Item No. **Report of the Head of Planning, Transportation and Regeneration**

Address 11 CARNARVON DRIVE HAYES

Development: Erection of two storey attached dwelling with associated parking, amenity space and widening of existing dropped kerb (following demolition of single storey side extension and outbuilding)

LBH Ref Nos: **35377/APP/2021/3311**

Rev	Date	Amendment
CLIENT		
MR. & MRS RAM		
11 CARNARVON DRIVE		
HAYES		
UB3		
PROJECT		
PROPOSED		
Site and Location Plan		
DATE		
31.08.20		
SCALE		
1:200 and 1:1250 @ A1		
DRAWN		
NA		
REV		
DRAWING NUMBER		
1182-P-020		
Neha Abayawardana RIBA		
abay.architecture@yahoo.com

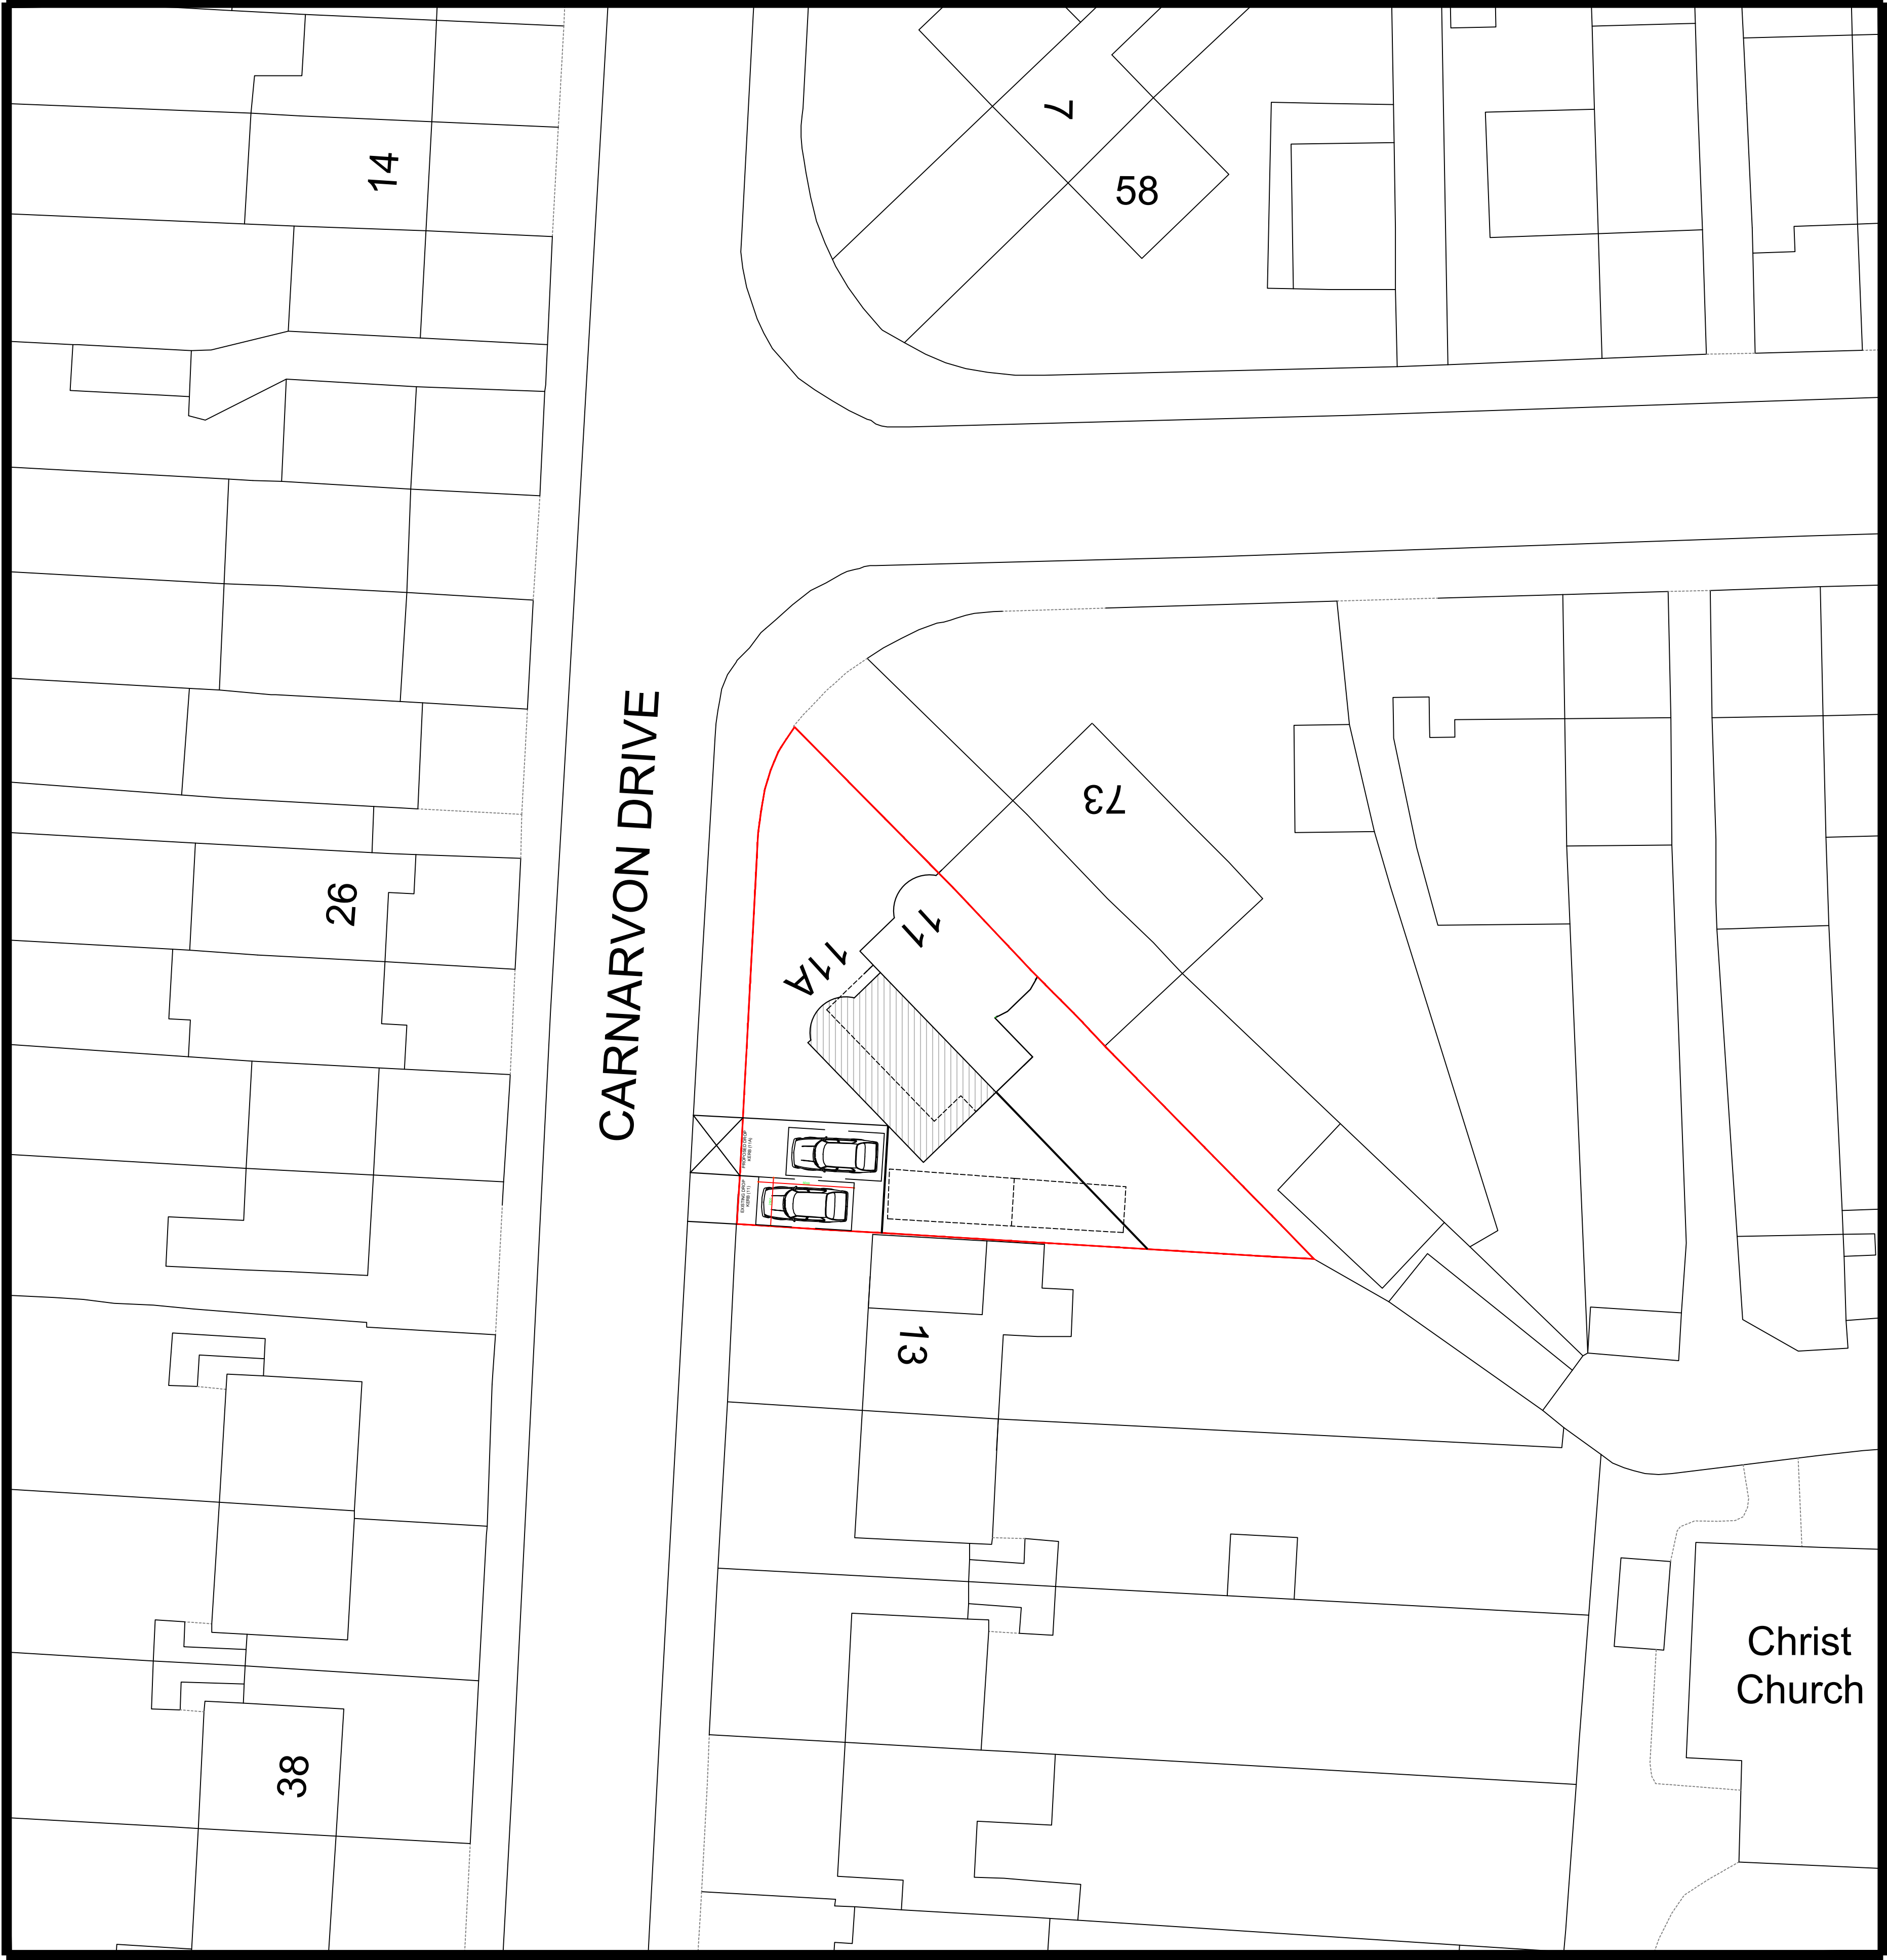
This concern has not been fully addressed in this revised application. Whilst the proposed dwelling has been set back from that which was previously refused (increasing the gap from the front boundary from 2.7m to 3.175m, the breach of the return building line is still significant (albeit less than previously refused). The proposed development, by reason of its siting in this visually prominent position, projection forward of the recognised established return building line along Carnarvon Drive, size, scale, layout, width and detailed design would constitute an incongruous and cramped form of development resulting in the loss of the open aspect of this prominent corner plot. The proposal would therefore represent an overdevelopment of the site to the detriment of the character and the visual amenities of the area and to this existing open area of the street scene. Therefore the proposal is contrary to Policy BE1 of the Hillingdon Local Plan: Part One - Strategic Policies (November 2012), DMHB 11, DMHB 12 and DMHD 1 of the Hillingdon Local Plan: Part Two - Development Management Policies, Policies D3, D4 and D6 of the London Plan (2021) and the NPPF.

The proposal indicates that the existing dwelling would be served by a single parking space accessed by the existing dropped kerb adjacent to the side boundary with No. 13 Carnarvon Drive and the new dwelling would be served by an adjacent single parking space, served by a new crossover extension, 2.4m wide. The Council's Highway Engineer has reviewed the proposed parking arrangements and advises that on balance, as the difference between the requirement (of up to 2 spaces per unit) and provision is marginal, the single space provision is considered acceptable. Also, there is no 'in-principle' objection to the extended vehicular crossing off Carnarvon Drive which would facilitate replacement on-plot parking for the main address and the new dwelling, although the revised access provision would need to be facilitated at the developer's expense with conformity to the Council's 'Domestic Vehicle Footway Crossover Policy' in terms of dimension and build quality. All works would be arranged post-permission via a formal agreement i.e. under s184 of The Highways Act 1980 or suitable alternative arrangement.
